Householder Application for Planning Permission for works or extension to a dwelling.
Town and Country Planning Act 1990

Proposed single storey extensions and new car port - see attached e-mail

RE: Proposed single storey extensions and new car port
 AT: 1 St Mary's Drive, Langho

title
Proposed Plan, Elevations & Section

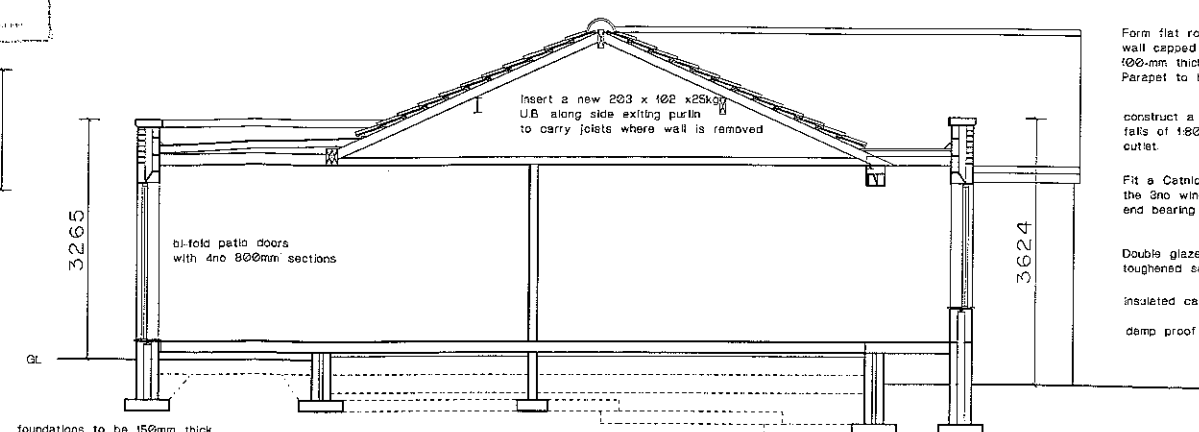
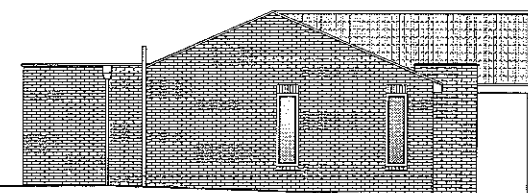
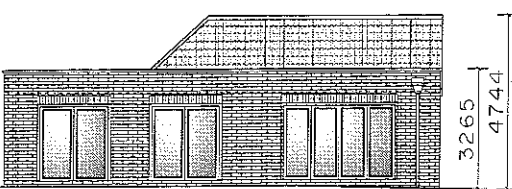
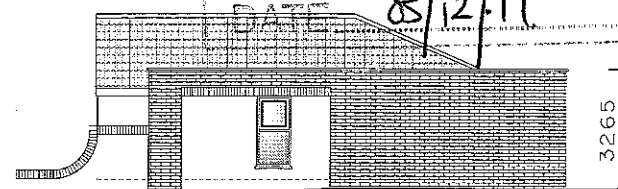
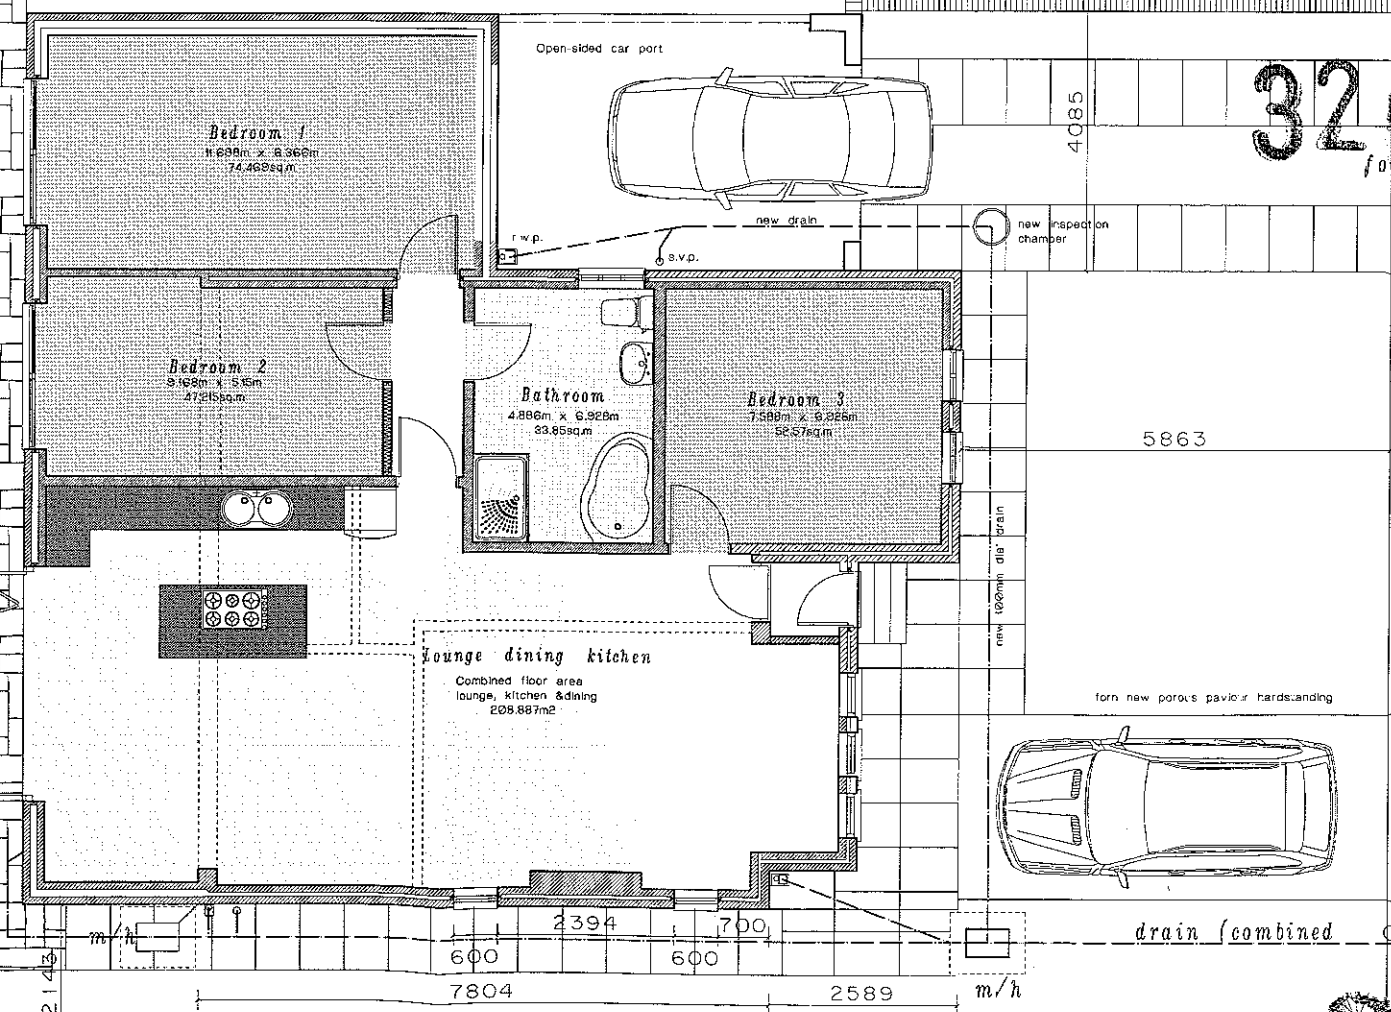
- Are you happy for the description to read 'Proposed single storey extensions to side and rear, conversion of existing garage into bedroom and erection of open-sided car port to side elevation'?
- We appreciate that the heights have been marked on the existing section through the site but please can you add the the overall height of the proposed extension (including the parapet wall). This helps for when the plans go on the website.

I agree to the description being amended. I have added dimensions to the drawing as requested
